**Re: 410-416 Victoria Avenue - DPHI Response to Submission 4th June 2025 & Willoughby City Council Letter 2nd June 2025**

This letter provides commentary and clarification in response to the points raised in the Willoughby City Council (WCC) Letter dated 2<sup>nd</sup> June 2025, specifically the items detailed in Section 16.a.iii Stormwater Management.

3 SUBSTATION SECTION

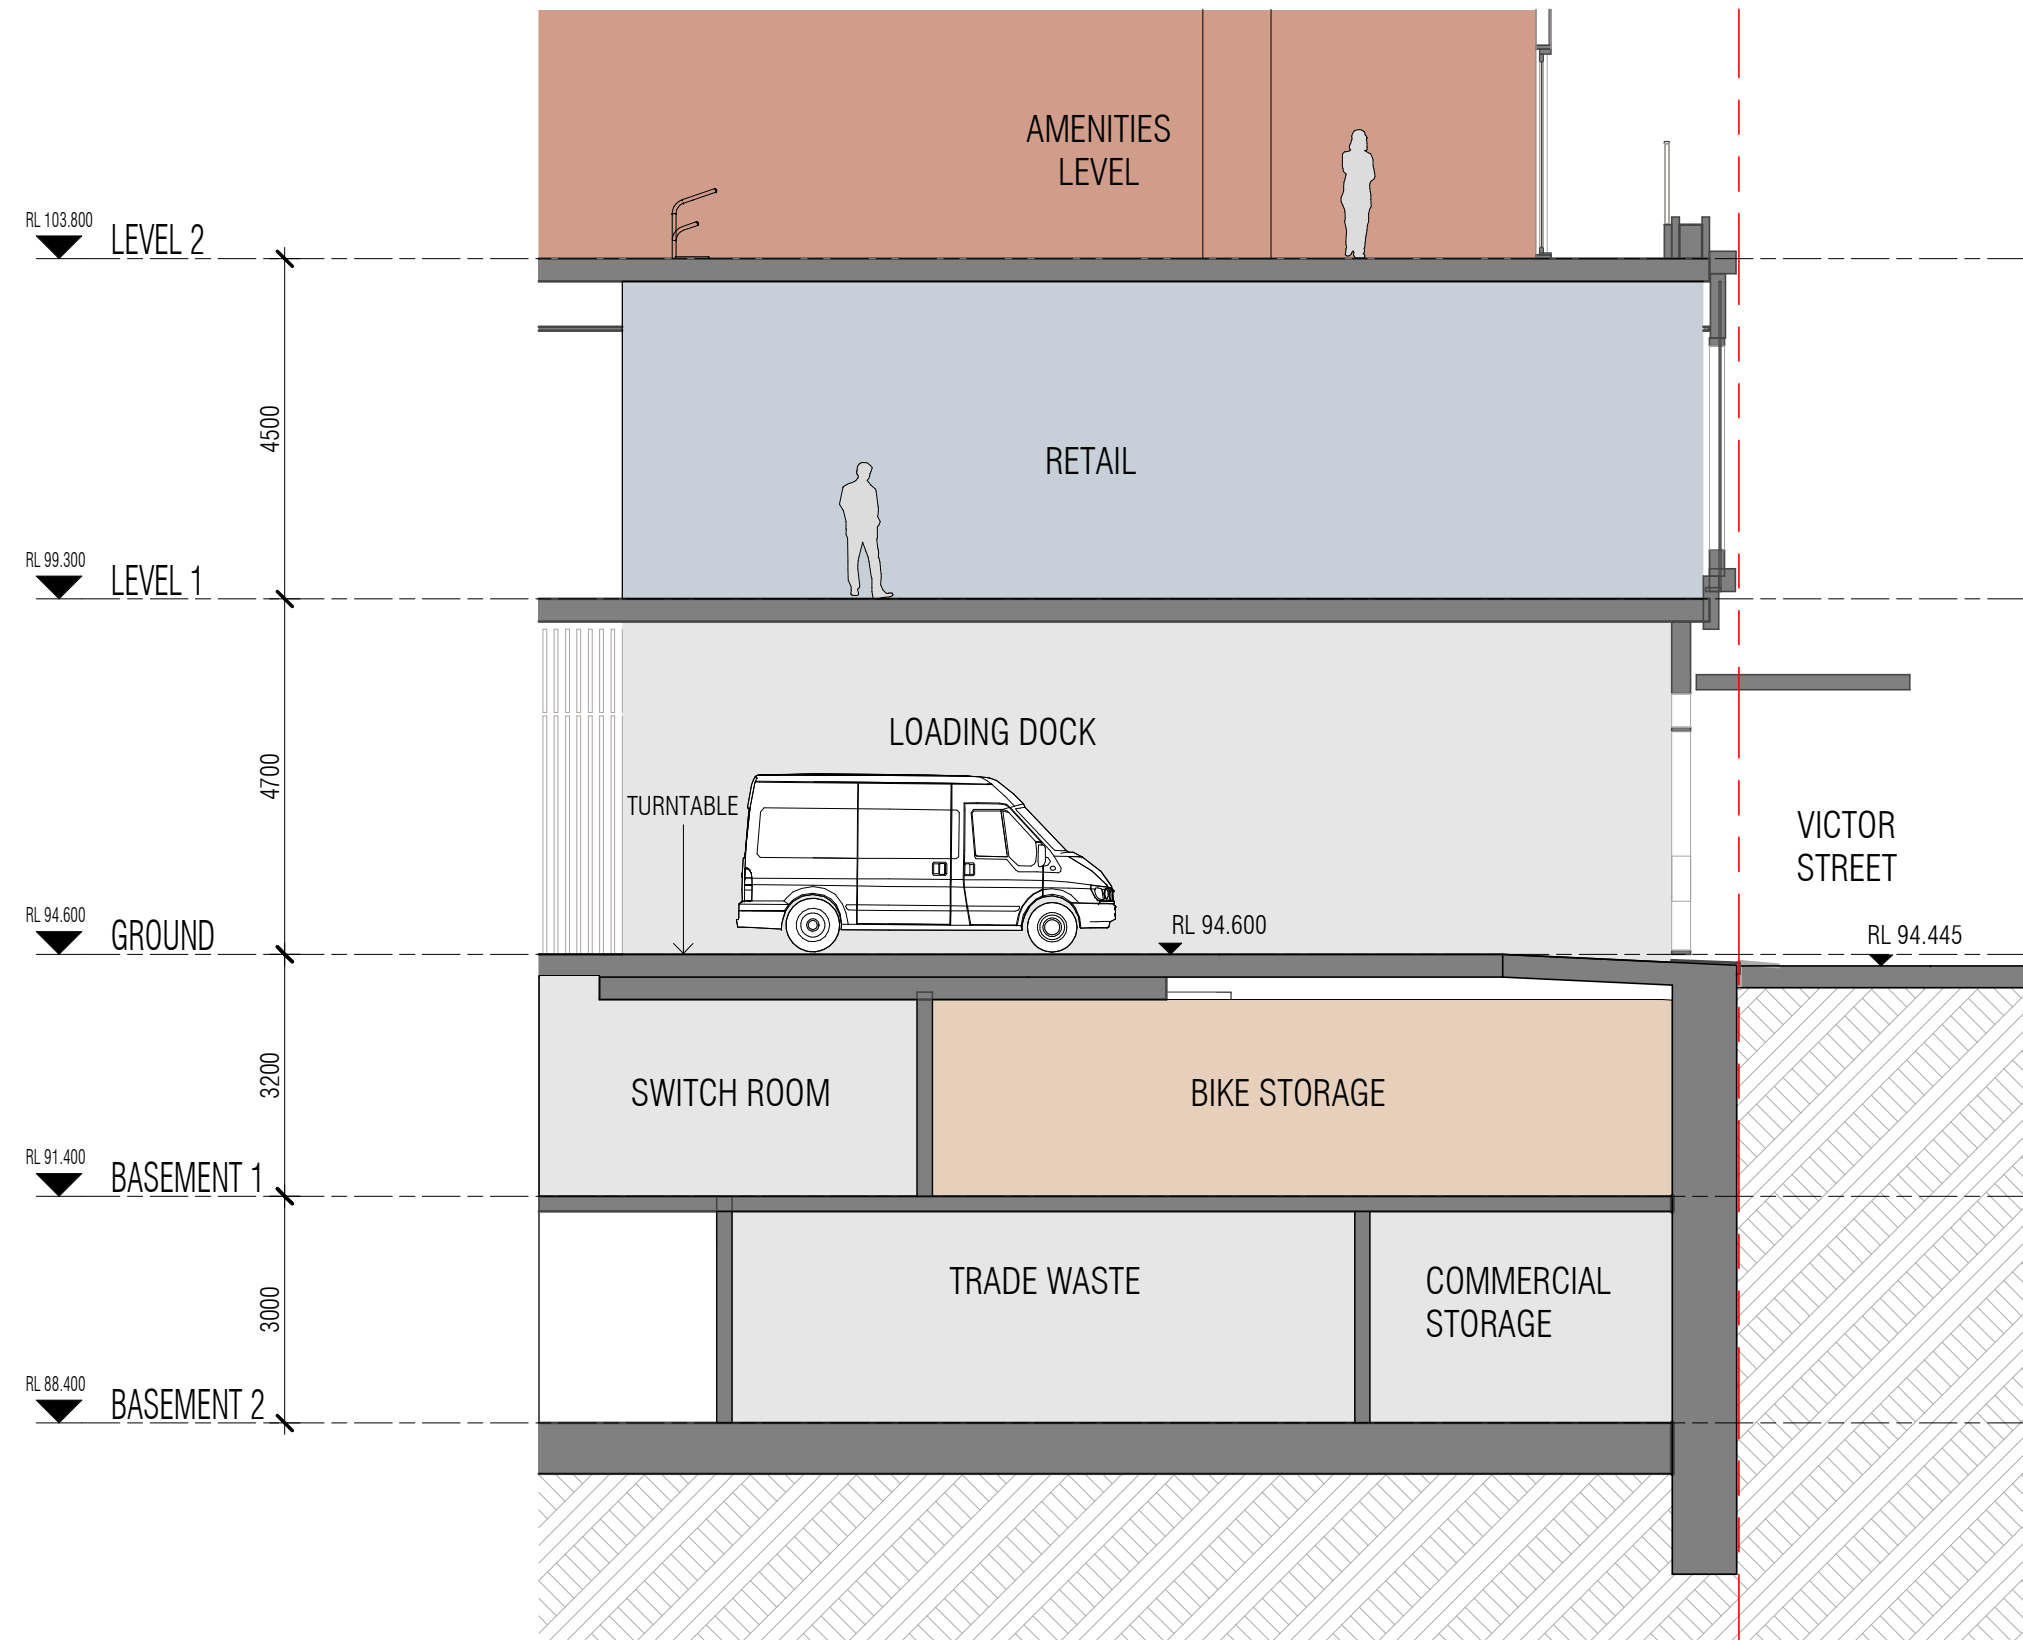
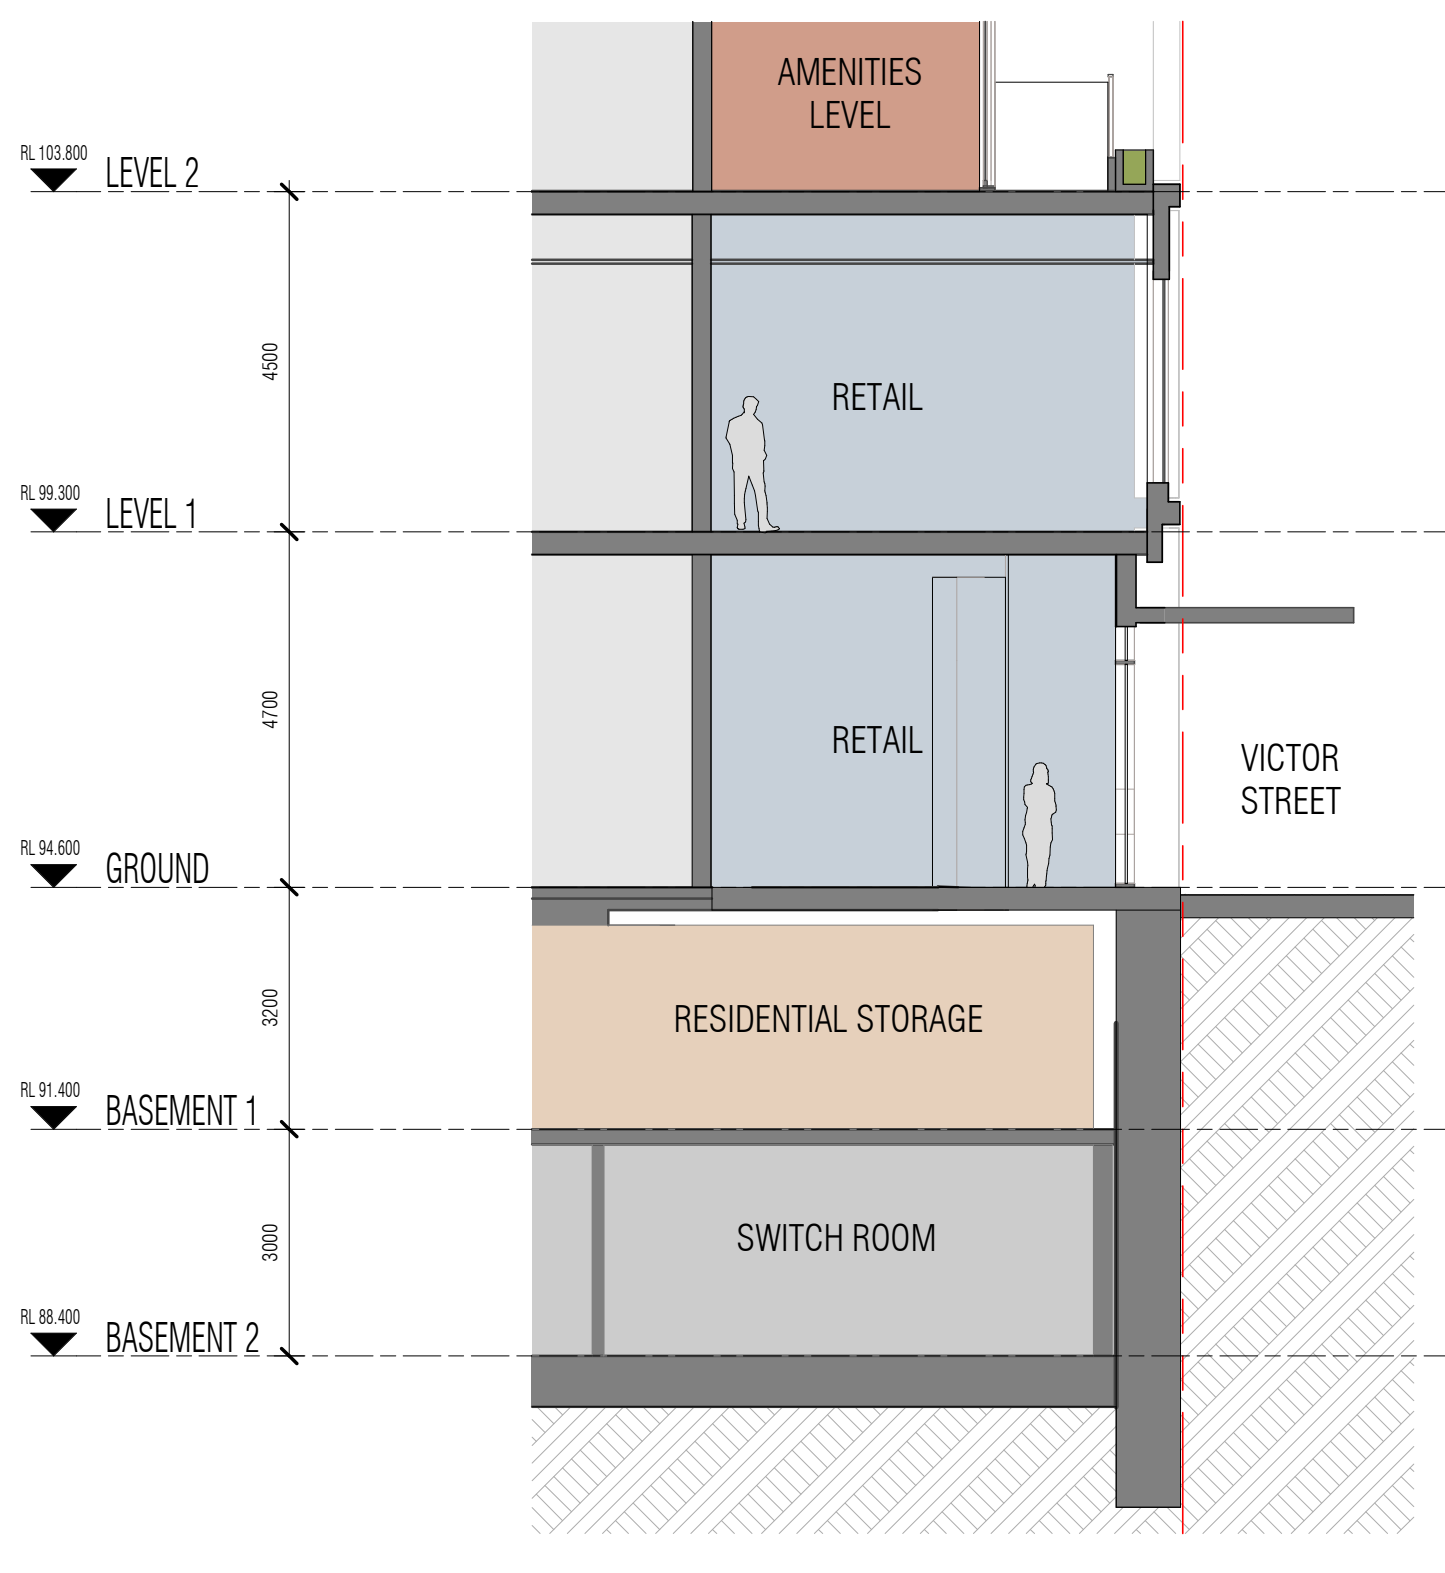
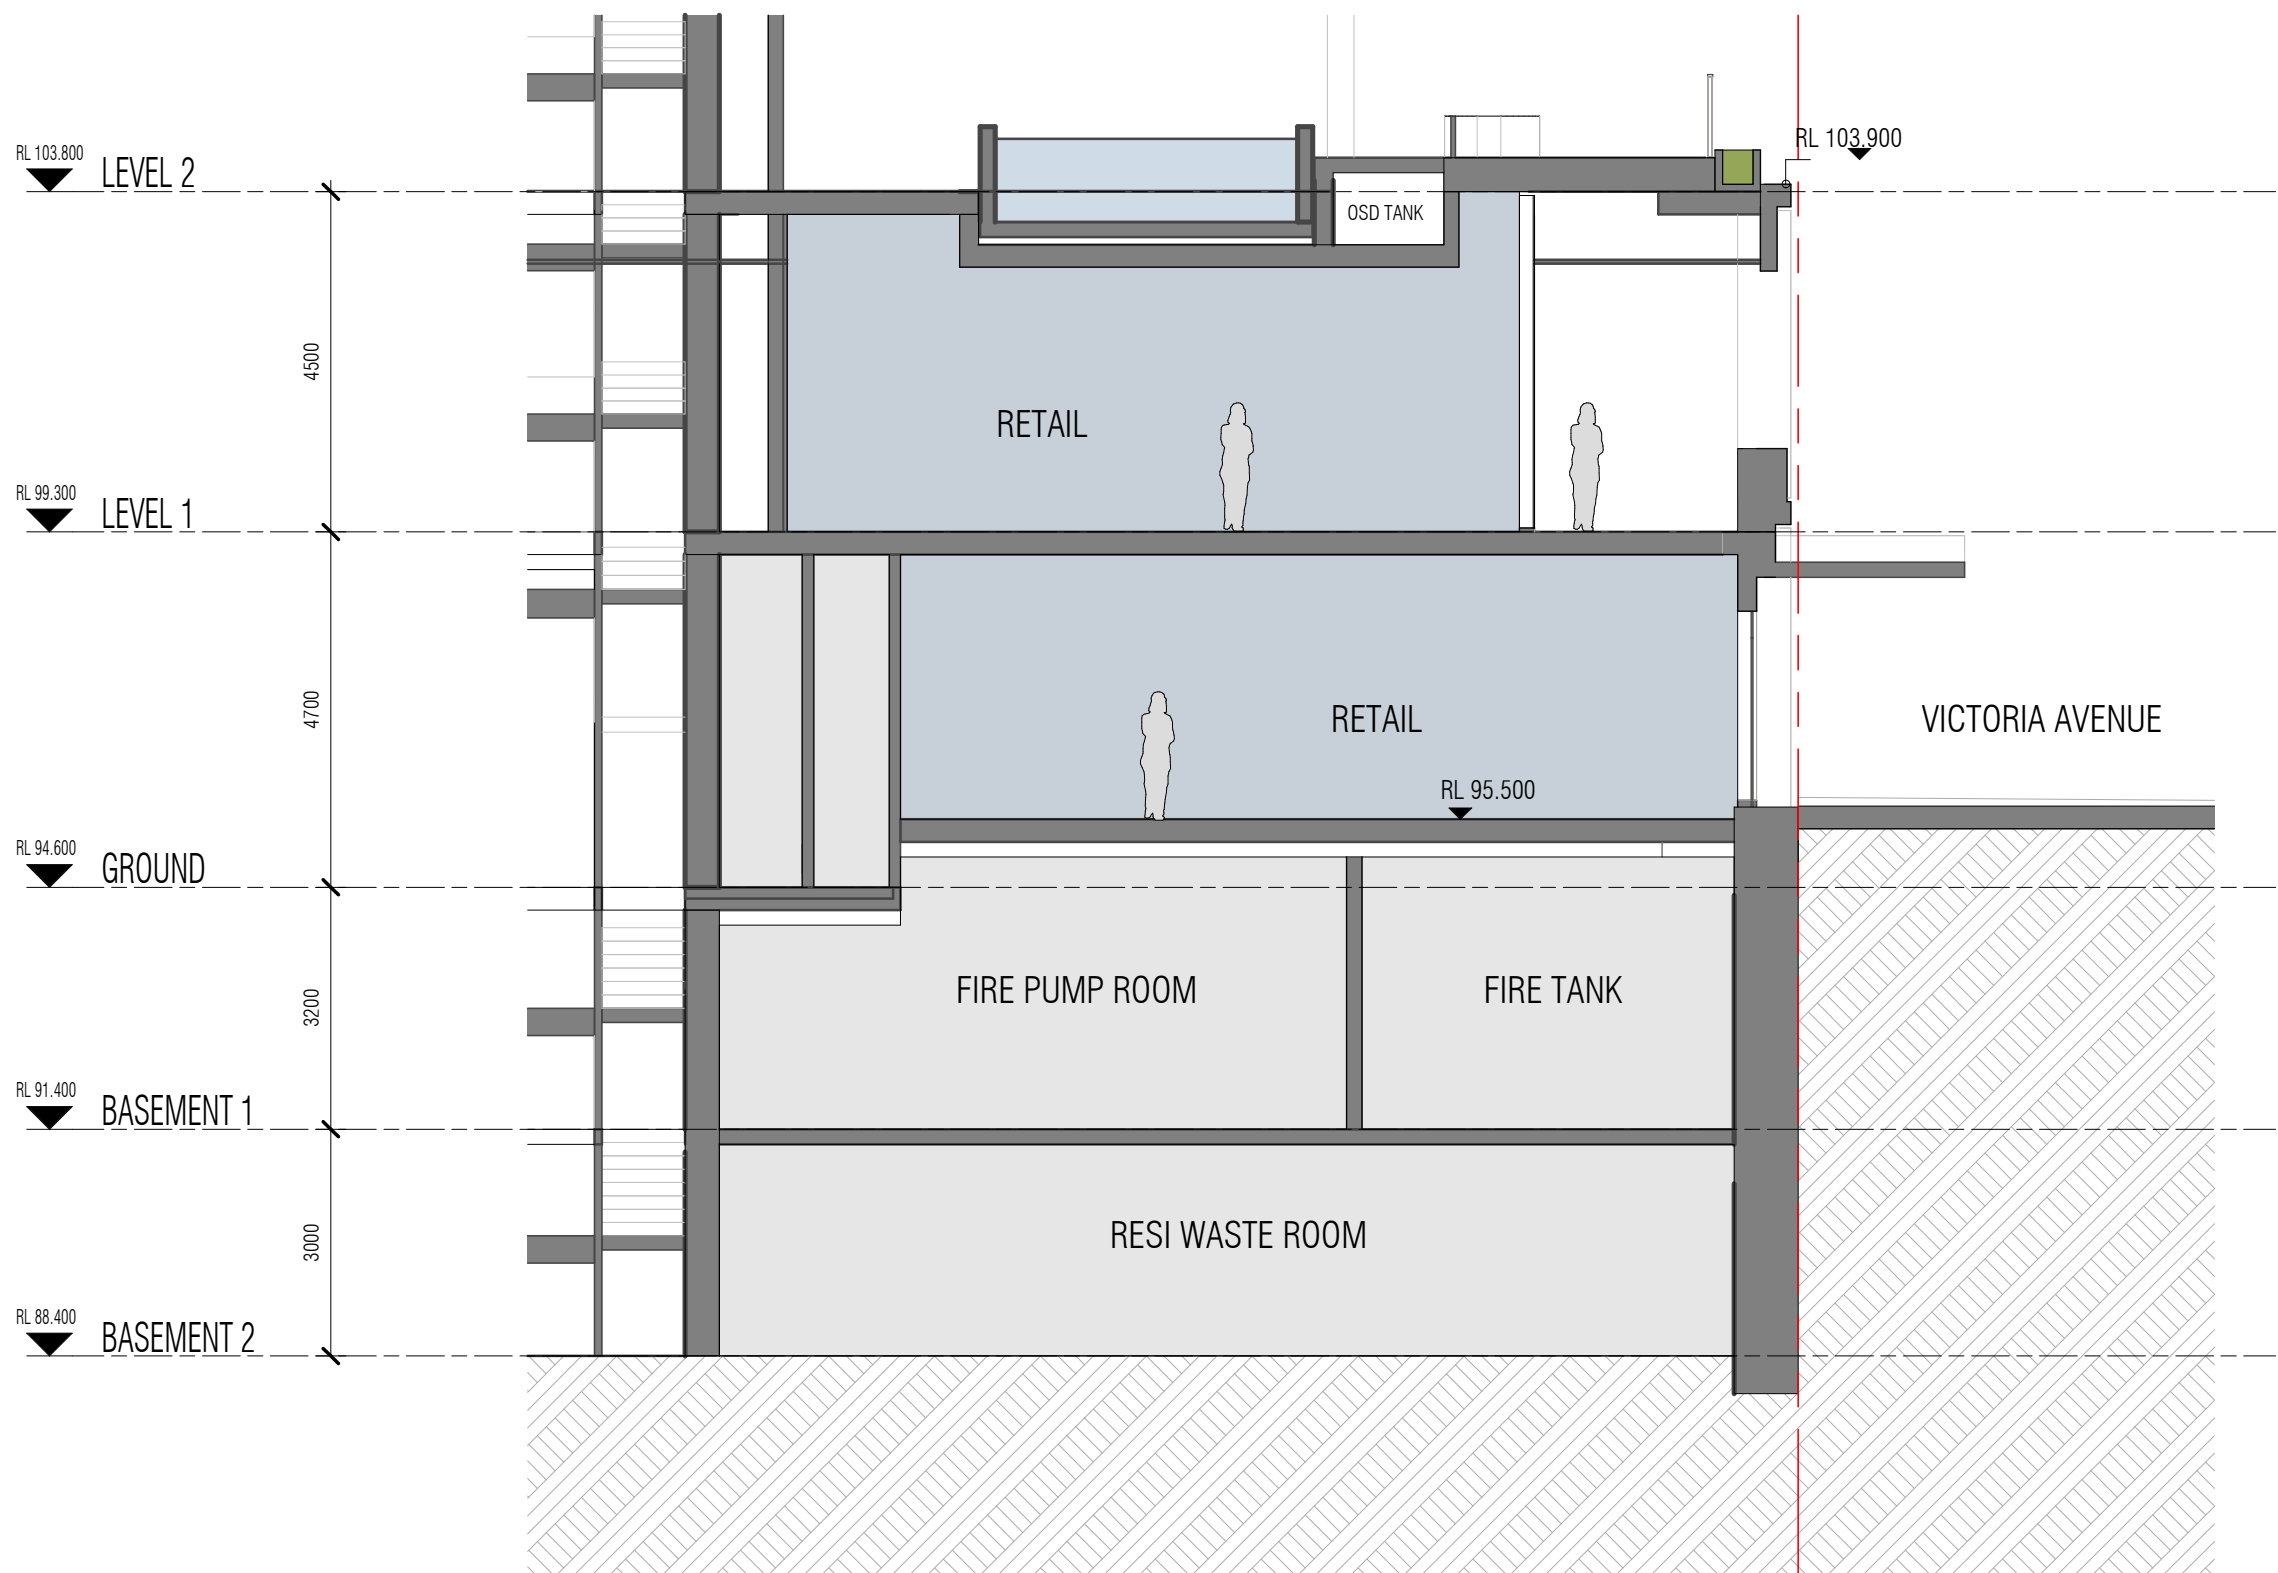
*WCC Comment: All below ground OSD tanks is not be located underneath habitable floors and are to have access grate diagonally opposite the outlet for ventilation and cleaning purposes. It is not demonstrated how access for maintenance requirements, preventing the mixing of pool water and OSD will be managed. It is not clear how the below ground OSD is accessible in line with AS 286.5- Safe working in confined spaces with no step iron provided for OSD tanks deeper than 900mm.*

The proposed OSD is not located below ground; instead, it is suspended at Level 2 slab level due to the shallow depth of the existing stormwater infrastructure along Victoria Avenue.

The pool coping is set at RL 104.66, which is 400mm higher than the adjacent pool terrace and the OSD top lids. This elevation difference ensures that stormwater cannot enter the pool. Additionally, the pool is fully covered, eliminating the risk of overflow from rainfall. Refer to architectural drawing DA252 for detailed pool levels.

Step irons can be installed in all OSD access lids, with details to be provided during the Construction Certificate (CC) design stage.
